M3J9

Submission

Winchester Action on the Climate Crisis

PROPOSED M3 JUNCTION 9 GYRATORY
CH-HML-E_RNBT_01-M2-VFK-ALIGNMENTRE-0001
 SCALE: Hz 1:1000, Vt 1:200

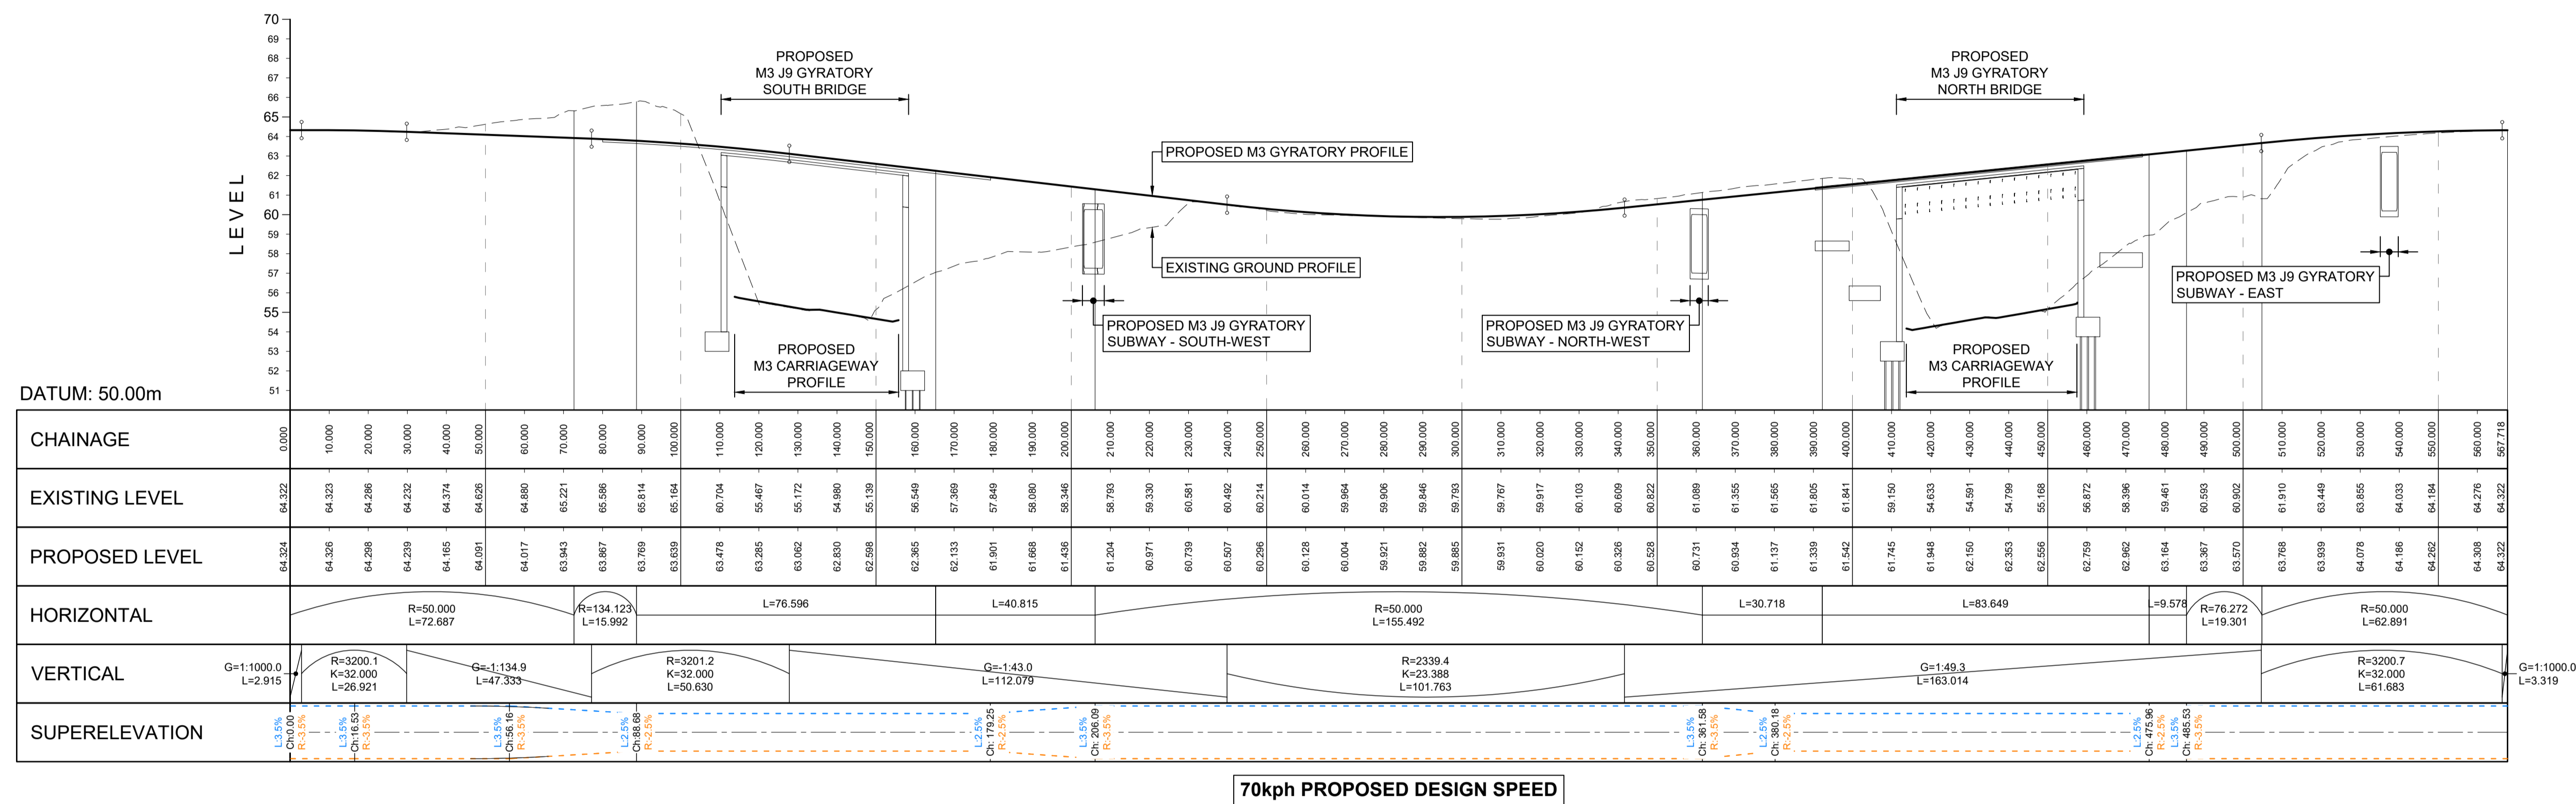
The analysis of emissions associated with construction is far more thorough and accessible than the analysis of end-user emissions. The problem with construction emissions lies elsewhere. The proposals unnecessarily involve **too much demolition of reusable infrastructure**. For example the central J9 roundabout could be adapted to the revised traffic flow rather than demolished and rebuilt.
